An
Coimisiún
Pleanála

Commission Order
ABP-320327-24

Planning Authority: Wicklow County Council

Planning Register Reference Number: EX53/2024

CLIENT	Tondo Ltd.		
JOB TITLE	Development at Kippure Estate		
LOCATION	Manor Kilbride, Blessington, Co. Wicklow		
STATUS	Pre-Planning		CHECKED AB
DRAWN	NF		APPROVED AB
DRAWING No.	PL-0708-01-KE	DRAWING TITLE	REVISION
		Structure 07 & 08

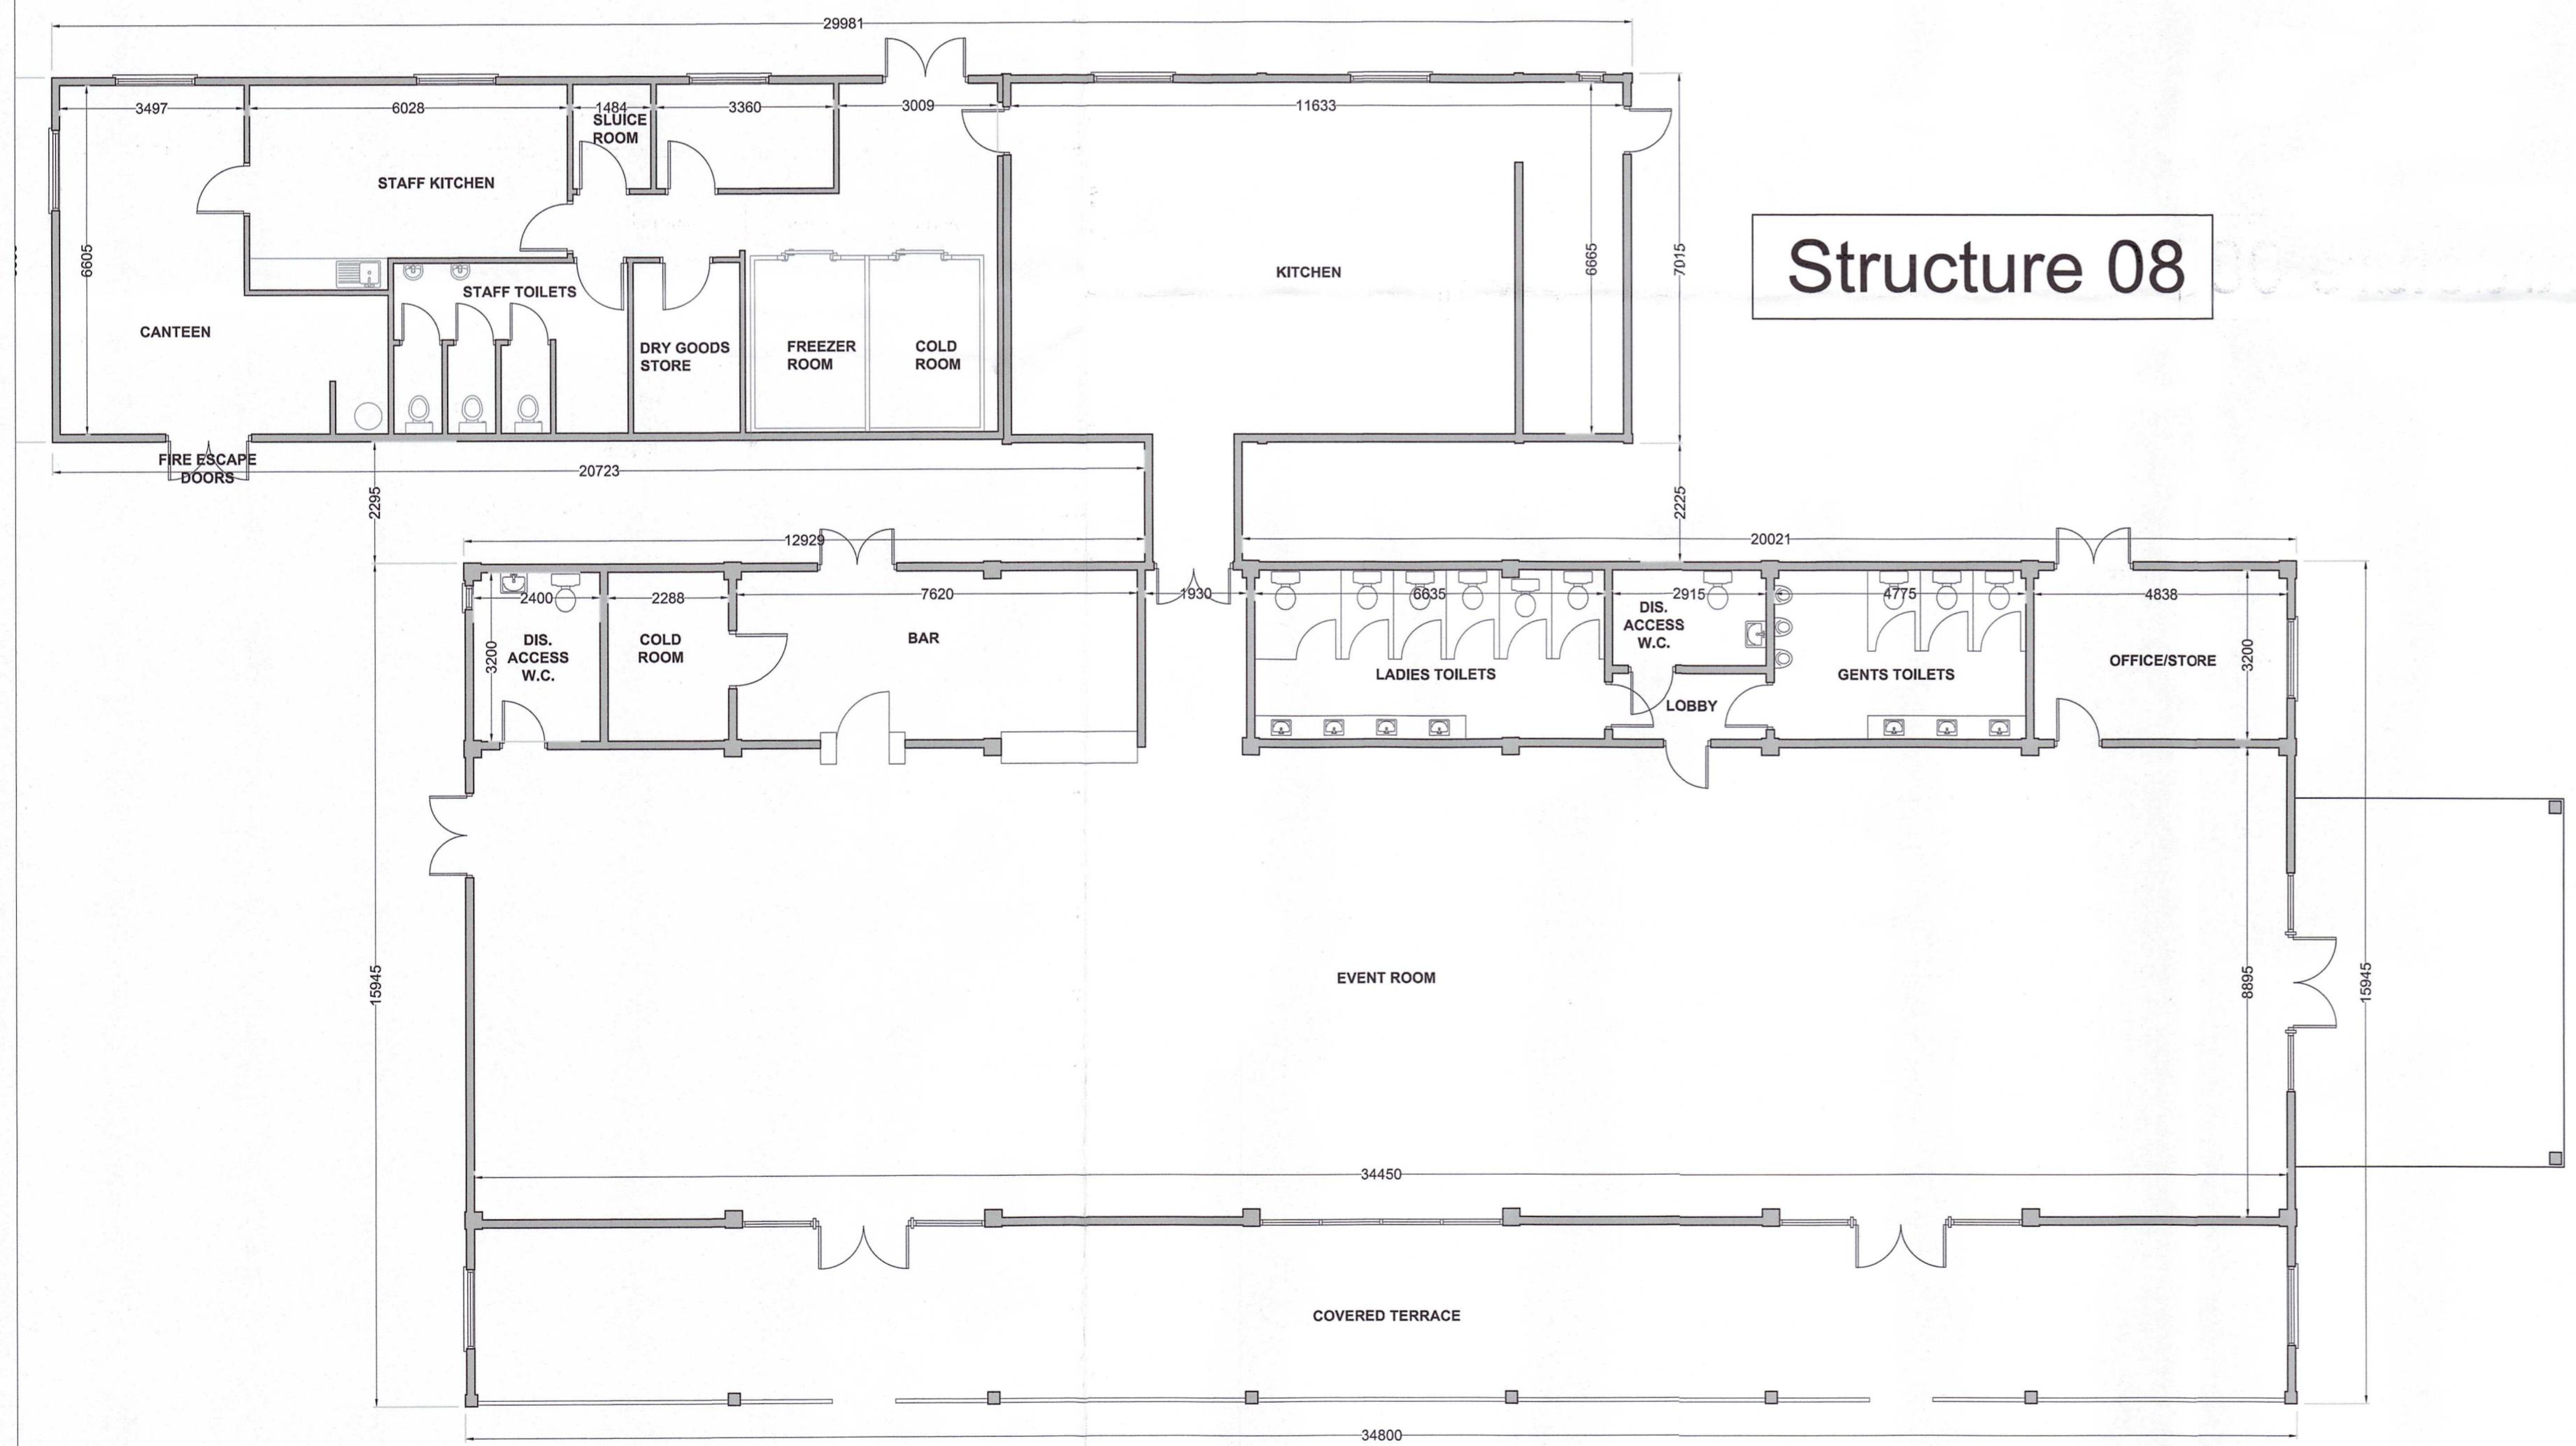
- (g) Structure Number 7 and Structure Number 8: The construction of the pavilion and kitchen buildings do not come within the scope of Section 4(1)(h) of the Planning and Development Act 2000, as amended, as they are new structures. Therefore, these structures do not constitute exempted development.
- (h) Structure Number 10: Having regard to the significant nature and scale of the works to the original structure 'Belfry' and the development approved under planning authority Register Reference 05/2792 the works do come within the scope of Section 4(1)(h) of the Planning and Development Act, 2000, as the works materially affects the external appearance of the structure so as to render its appearance inconsistent with the character of the structure. Therefore, the works do not constitute exempted development.
